**REQUEST**

Current Zoning: B-2(CD) (general business, conditional)  
Proposed Zoning: B-2(CD) SPA (general business, conditional, site plan amendment)

Approximately 1.263 acres located on the north and south side of Northlake Creek Drive, west side of Reames Road, and south side of West W.T. Harris Boulevard.

The petition proposes to amend an existing approved rezoning site plan to allow for the development of EDEE and commercial uses with accessory drive-through lanes on an out parcel within an existing shopping center.

SHEET TITLE:
SCHEMATIC SITE PLAN

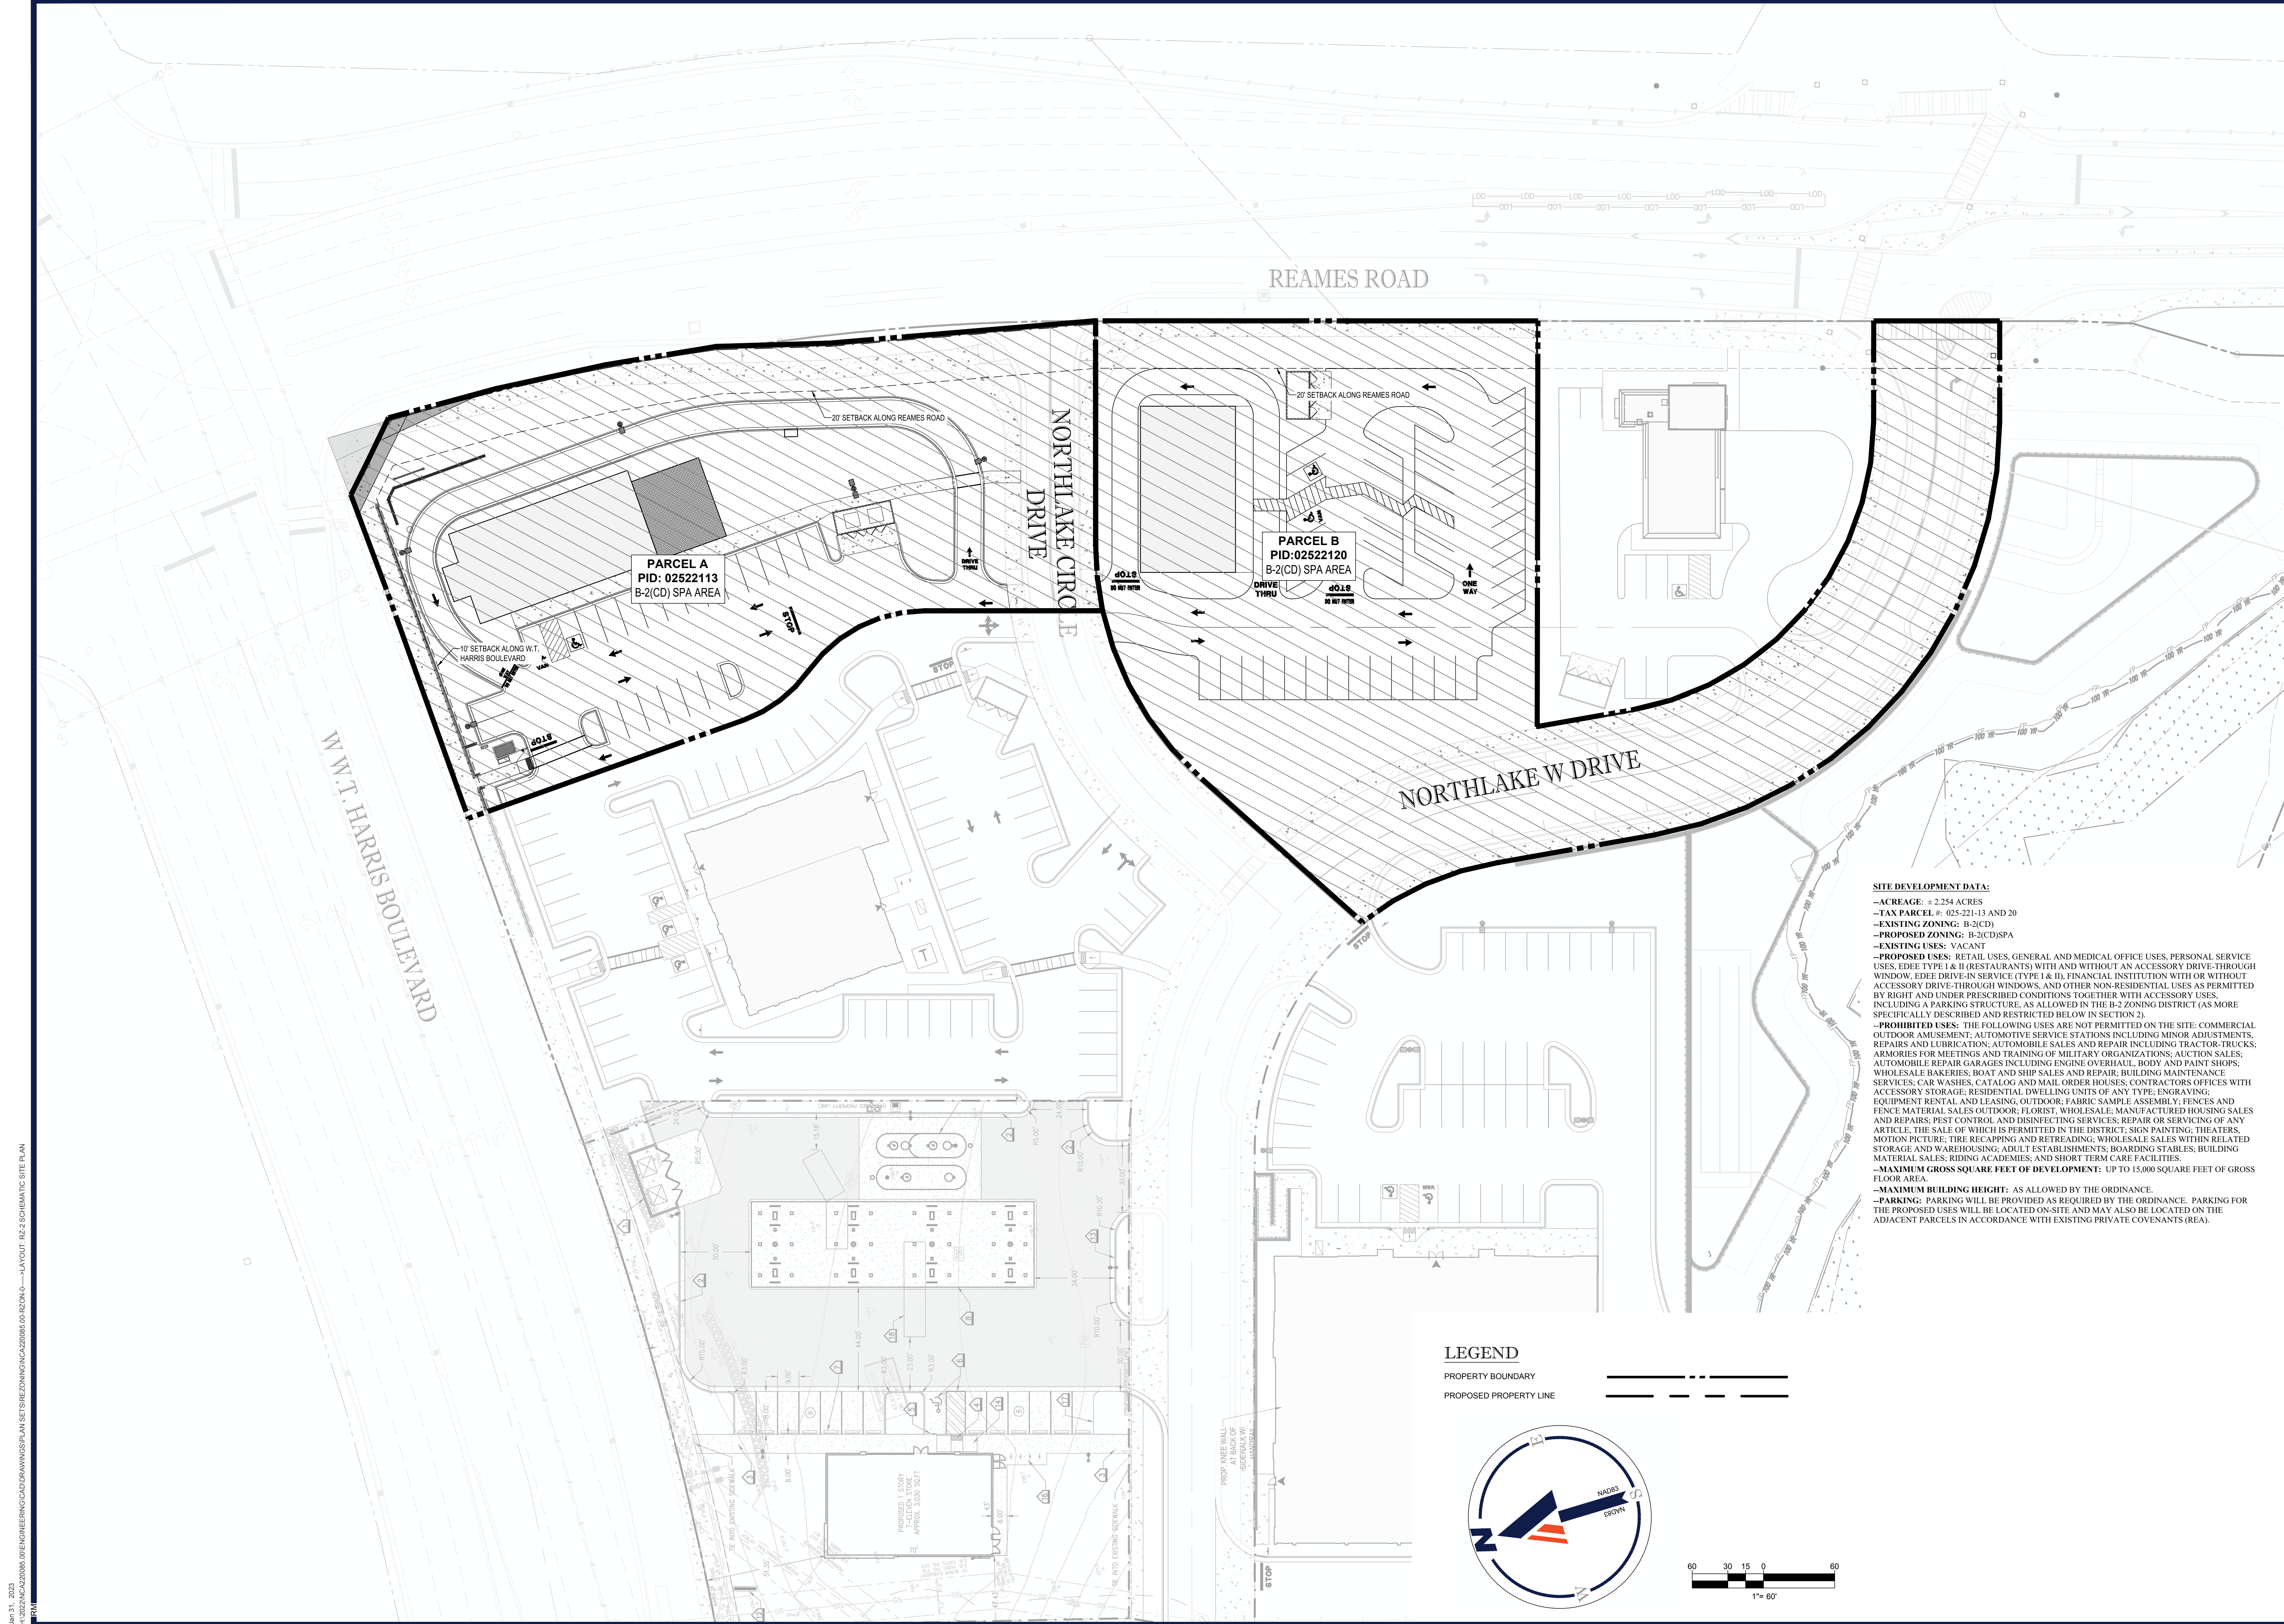
and/or conditional note revisions are needed to commit to labeling and dimensioning the future curb and gutter. Site plan continues to commit to multi-use path on W.T. Harris and streetscape improvements, and related mitigations found through the approved Traffic Study.

- ~~1. W T Harris Blvd: Location of future back of curb and gutter to be 44 feet from roadway centerline to accommodate the Charlotte Streets Map with a roadway typical section of 6+ Boulevard, Shared Use Path. **Addressed**~~
- ~~2. Reames Road: Location of future back of curb and gutter to be moved to 38 feet from roadway centerline to accommodate the Charlotte Streets Map with a roadway typical section of 4+ Avenue, Buffered/Separated Bike Lanes. **Addressed**~~

- ~~3. The proposed site plan shows two principal structures on the site, while the conditional notes refer up to four proposed principal structures. The proposed number of structures shown on the site plan and noted in the conditions must match. **Addressed**~~
- ~~4. Staff recommends that the site plan be revised to incorporate design elements that would increase the consistency of site with the design requirements of the Regional Activity Center Place Type such as relocating the drive through lanes so that they are not located between the buildings and the street. **Addressed**~~
